From: [martyn_hussey](#)
To: [AwelyMor](#)
Subject: DESNZ letter 14th August Response
Date: 15 August 2023 15:36:17

Awel y Mor Offshore Wind Farm limited

In response to the Department for Energy Security and Net Zero letter dated 14th August 2023 asking for comments on the applicants environmental assessment in relation to additional cumulative effects, I would like to make the following comments.

Figure 1.1: Site location with mitigation zone outlined in red

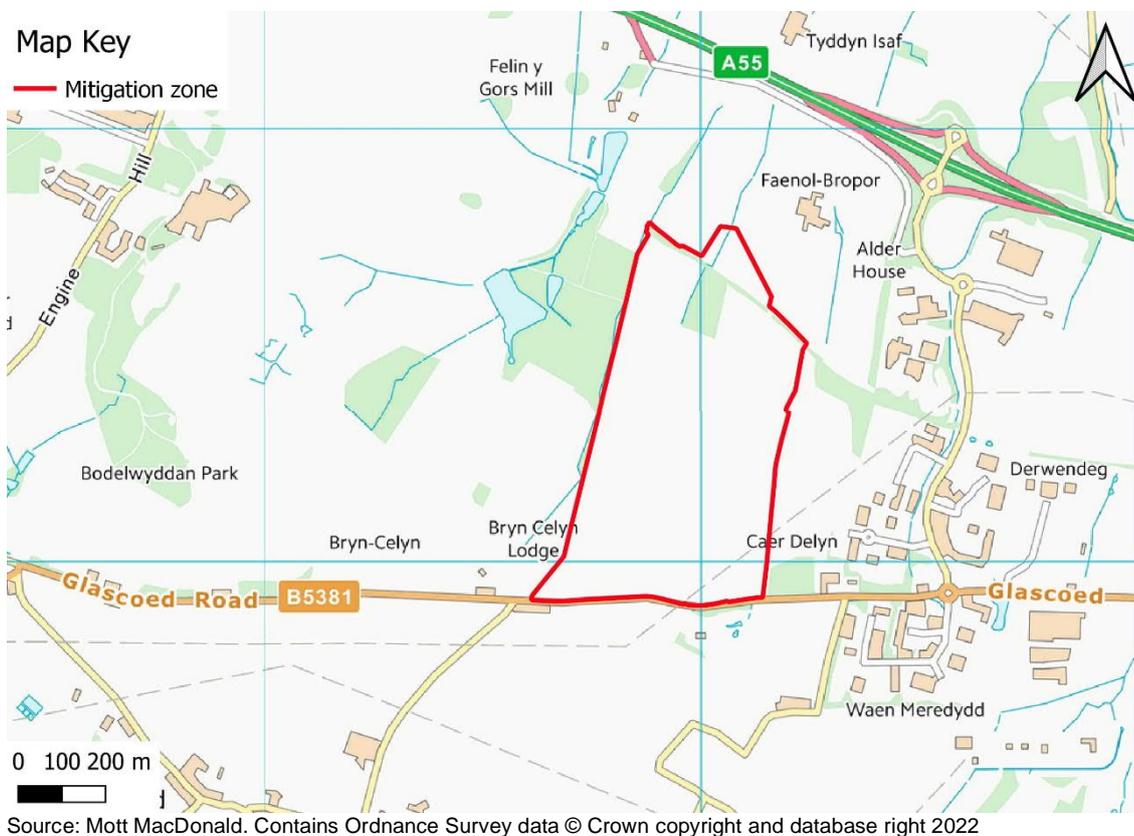
- Awel y Mor plan on acquiring 83 acres of freehold for their onshore substation
- Whilst Gwynt y Mor installed gas insulated switchgear and Awel Y Mor are likely to install Air insulated switchgear and thus a bigger footprint of around 21 acres, it seems unreasonable that an additional 60 acres is required for screening/mitigation/drainage, unless there is an ulterior motive for such a large land acquisition?
- Perhaps they intend to follow Hornsea3 example and apply for further development (battery storage)in the future

I would therefore politely ask that you clarify the reasons for such a large land uptake and if indeed it is necessary for screening/mitigation/drainage then as part of any approval (should it be given) that these lands are protected from further development.
